From: Amanda Scholes on behalf of Planning.Responses
Sent: 03 November 2021 08:41
To: Planning Scanning
Subject: FW: LU/274/21/DOC - Croft Cottages, Littlehampton, BN17 5LS - UPDATED CONTAMINATION COMMENTS REQUIRED

From: Kate Giddings [REDACTED]
Sent: 27 October 2021 13:16
To: Amy Myer [REDACTED]
Subject: RE: LU/274/21/DOC - Croft Cottages, Littlehampton, BN17 5LS - UPDATED CONTAMINATION COMMENTS REQUIRED

The Contamination Mitigation Report does not constitute a satisfactory optional appraisal or remediation strategy, therefore parts 3 and 4 of the condition cannot be recommended for discharge. It will not be possible to recommend discharge of the entire condition until a separate Verification Report is provided on completion of groundworks on site (to include soft landscaping).

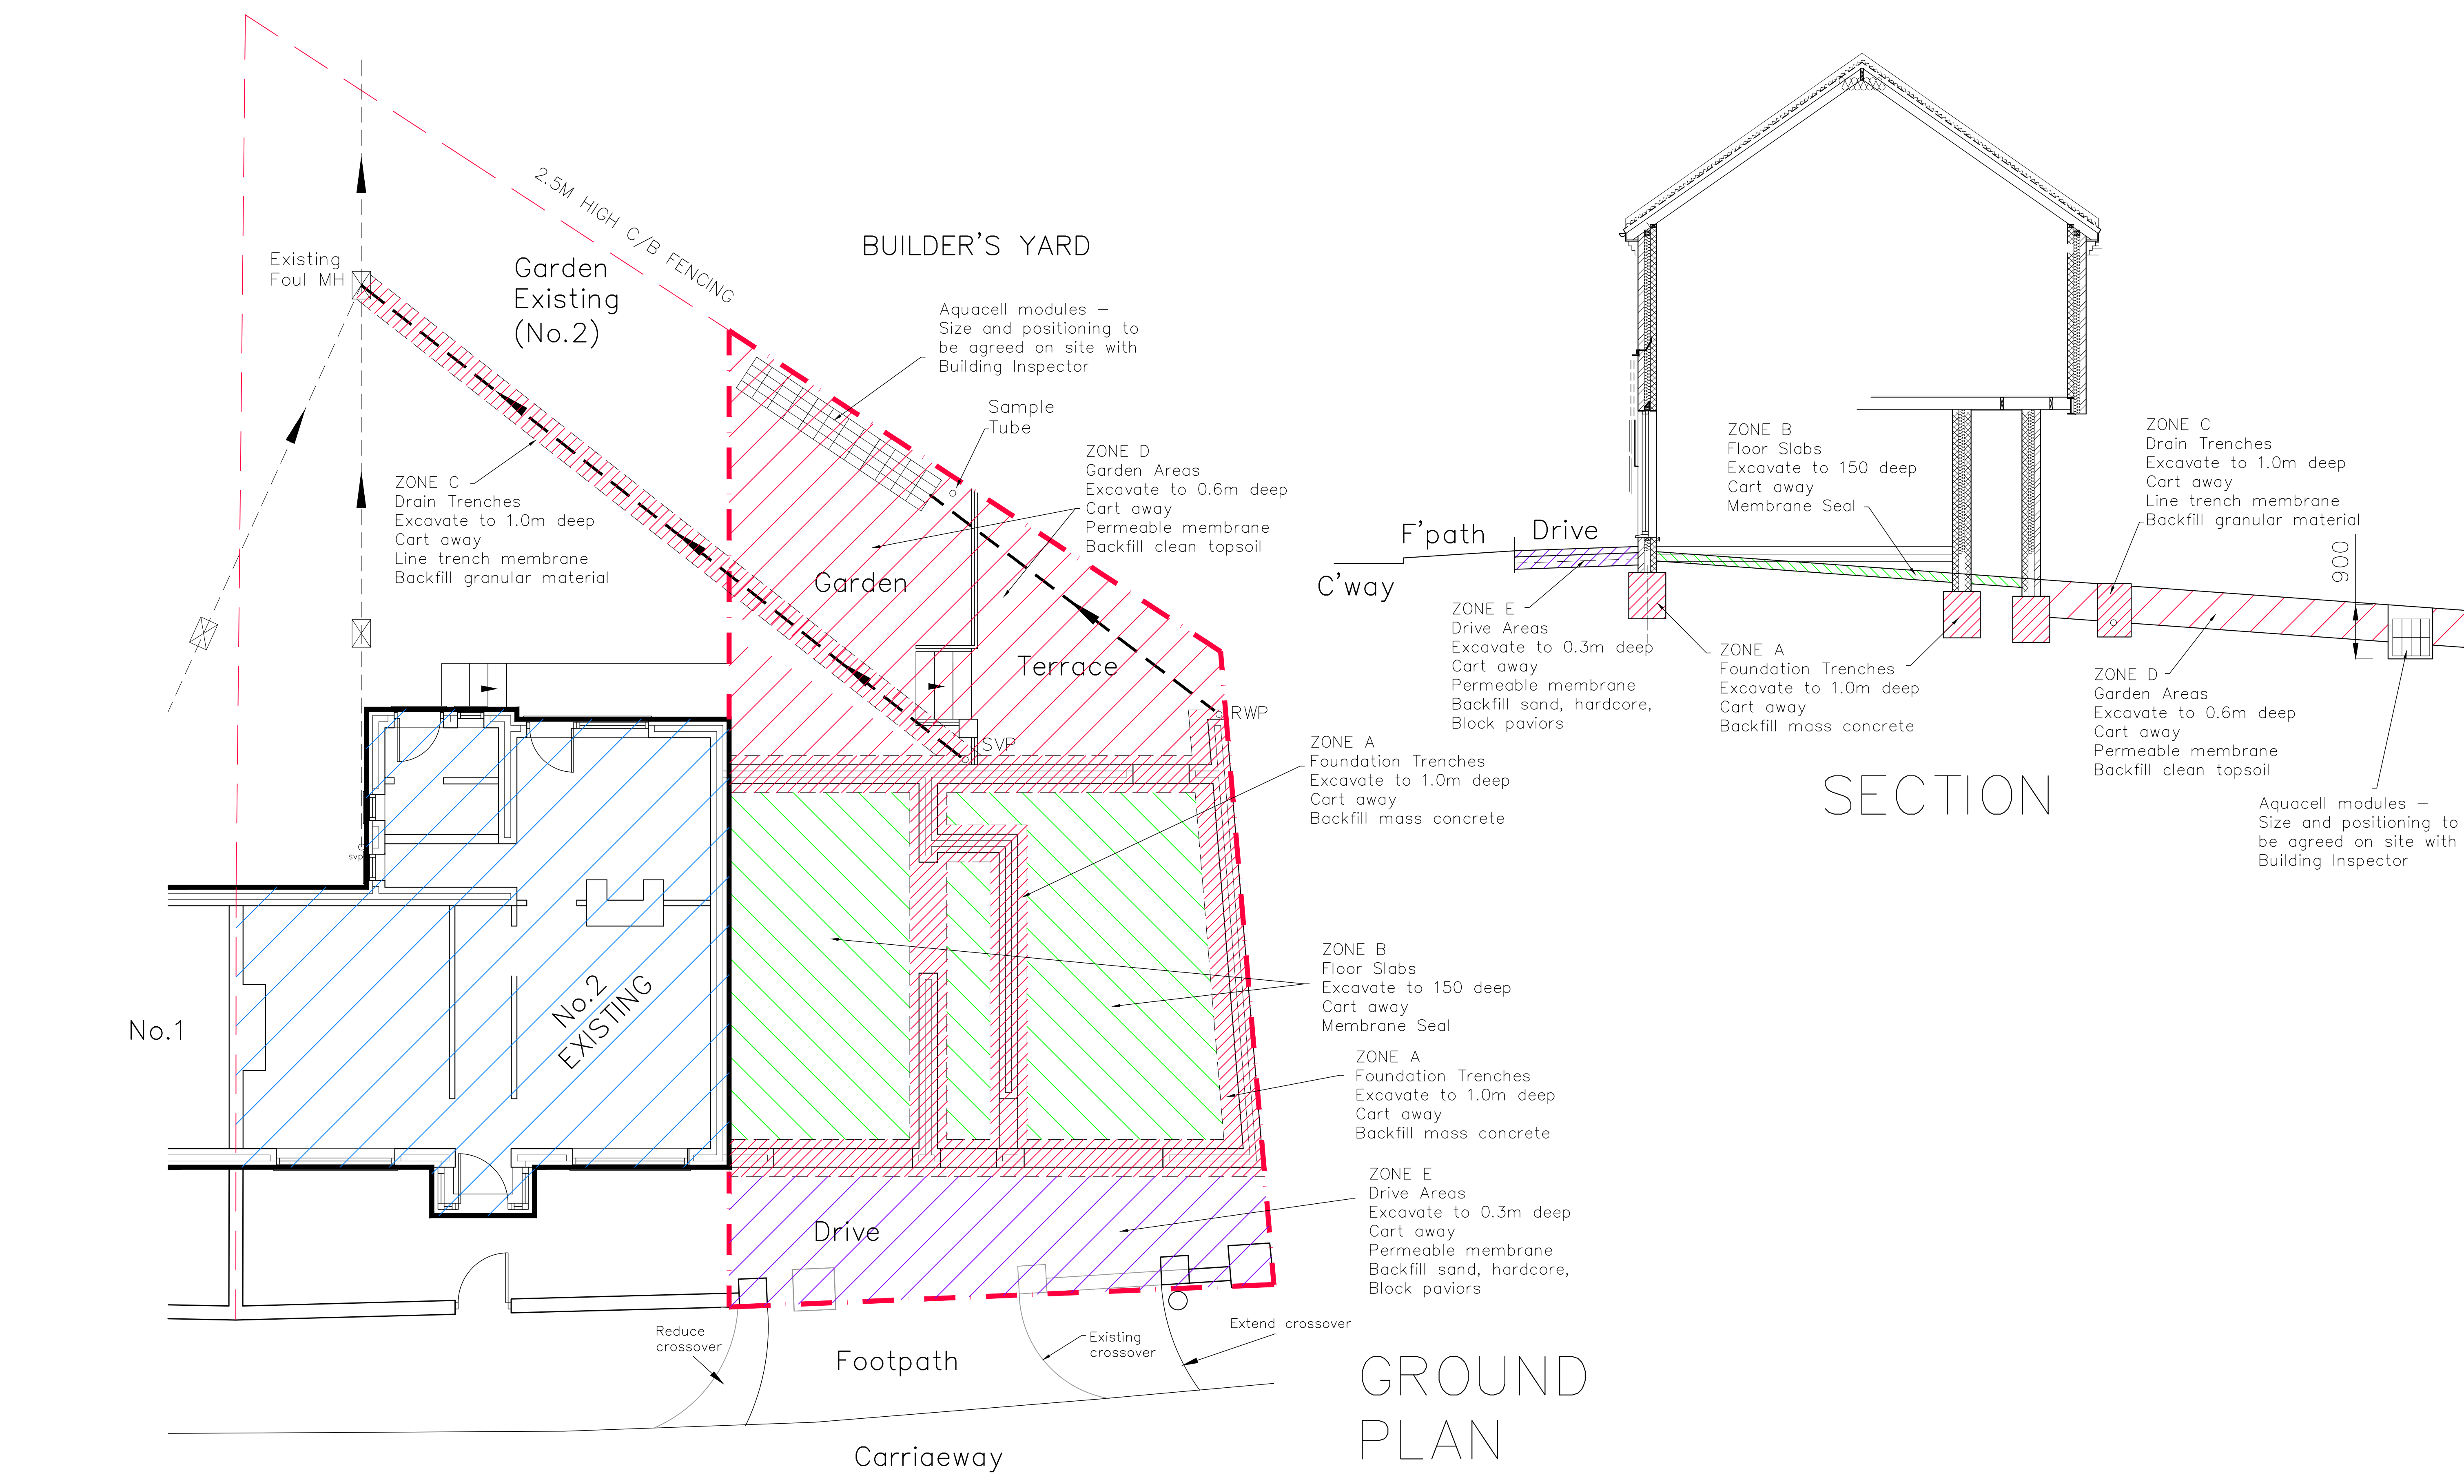
It is recommended that the Environment Agency is consulted with regard to the provision of soakaways in relation to the condition of the land.

#2
The intention of the Aquacell crates is that they will act as soakaways. Our starting premise is that the contaminated soil is to be removed, and with a working tolerance to the excavated depth, the source of contamination will be removed. Given the constricted nature of the site and the fall to the rear of the site, we consider the crates proposal to be the 'least worst' option. Southern Water Catch Pit 7851 to the north west is a negative fall from the site, and the storm sewer in Clifton Road is 60m to the east across private land. We also note that currently there is no formal storm drainage or water management on the site, with potentially contaminated run off passing, unrestricted, under the rear fence to the adjoining yard. Southern Water map extract attached.

#3
Condition 9 .3 and .4.
There is a paradox logic in the discharge of the overall condition, which requires approval to a scheme of risk management BEFORE work commences. The site investigation works required by .3 and .4 constitute a commencement of works. We assume this can be resolved with a partial discharge of the Condition, with a caveat as to the test results.
